REVIEW COMMENTS

Project:		NM385.01 - QT #7001 Unser Los Volcanes TIS			PDE:	
Review:					Reviewer:	
Date:		7/15/2024			Curtis Cherne (CABQ)	
#	PAGE	SECTION	COMMENT	AUTHOR	STATUS	RESPONSE
1	-	-	Unser Blvd is a Limited Access Roadway and therefore the driveway on Unser Blvd, Driveway 2, is not allowed.	CC	Discuss	<p>A third driveway on Unser is necessary to provide adequate ingress and egress, internal circulation, and separation of trucks and passenger cars. Without this driveway, drivers will have to make u-turns at traffic signals which are difficult to maneuver (especially for trucks) and add to congestion at traffic signals. The three driveway configuration provides the least number of truck vs vehicle conflicts while reducing upstream and downstream re-routes.</p> <p>The driveway was discussed with Matt Grush and was included in the approved conceptual layout. The driveway was also included in the "Conceptual Traffic Circulation Layout for DFT Approval" signed by Ernest Armjio.</p>

SHEET TITLE:
SITE PLAN

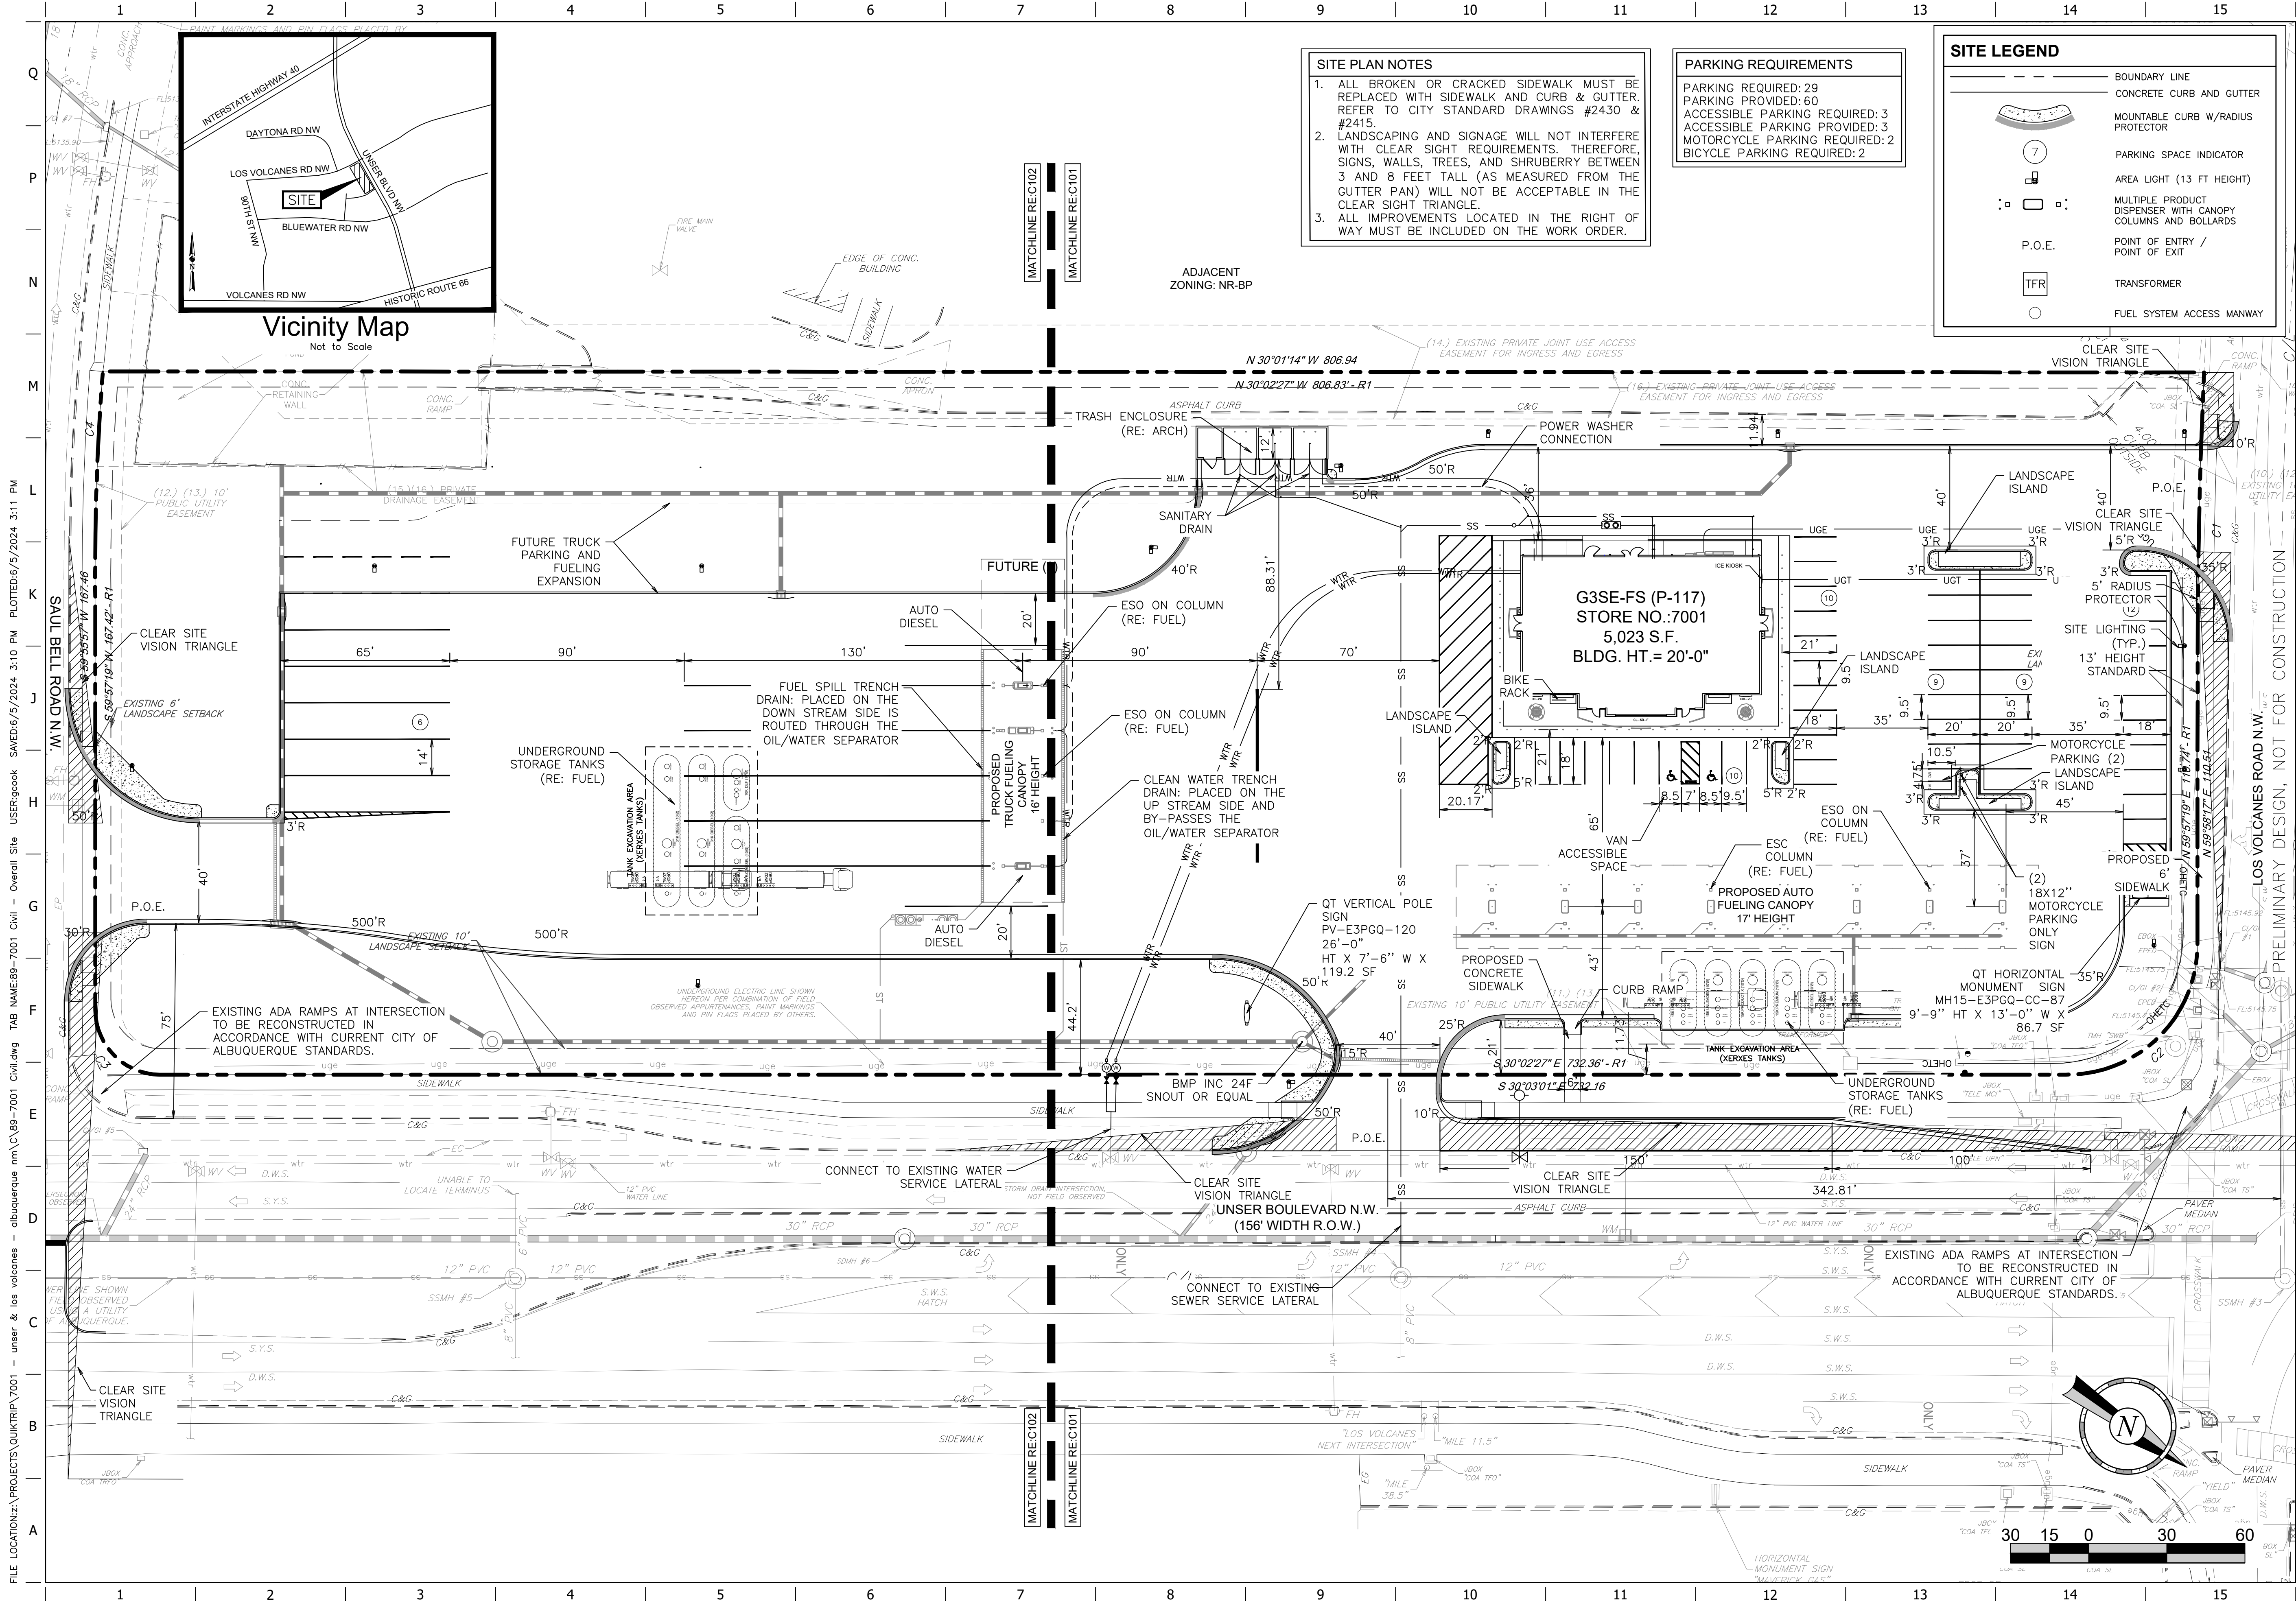
2	-	-	Site access is to be provided via two driveways: one on Los Volcanes Rd and the other on Saul Bell Rd.	CC	Discuss	<p>A third driveway on Unser is necessary to provide adequate ingress and egress, internal circulation, and separation of trucks and passenger cars. Without this driveway, drivers will have to make u-turns at traffic signals which are difficult to maneuver (especially for trucks) and add to congestion at traffic signals. The three driveway configuration provides the least number of truck vs vehicle conflicts while reducing upstream and downstream re-routes.</p> <p>The driveway was discussed with Matt Grush and was included in the approved conceptual layout. The driveway was also included in the "Conceptual Traffic Circulation Layout for DFT Approval" signed by Ernest Armjio.</p>
3	-	-	The driveway on Saul Bell Rd is to be located a minimum of 200 feet from Unser Blvd. It appears the west property line is approximately 285' from Unser Blvd. I am aware of the distances in DPM Table 7.4.45, however, per the Site Plan it appears the tractor trailer entrance is off of Saul Bell and the length of the tractor trailer combined with the reduced speed of leaving the roadway, queuing onto Unser Blvd may occur and should be prevented.	CC	Agree	Site Plan Updated

4	9	Background Information	Provide a cleaner image of Figure 1: Site Plan. Please include dimensions from the driveway(s) to Unser Blvd.	CC	Agree	Report updated
5	10	Study Area	On p. 10; the Study Intersections shown on Figure 2 don't match the listing in the paragraph below the Figure.	CC	Agree	Report updated
6	11	Streets	Please revise the description of Los Volcanes Rd on p. 11 as west of Unser Blvd it is a 2-lane undivided roadway.	CC	Agree	Report updated
7	-	-	In case more northbound drivers wish to enter the site via the Saul Bell Rd entrance than predicted in the Study, it would be helpful to have 150' of storage in the left turn lane onto Saul Bell Rd.	CC	Agree	Site Plan Updated
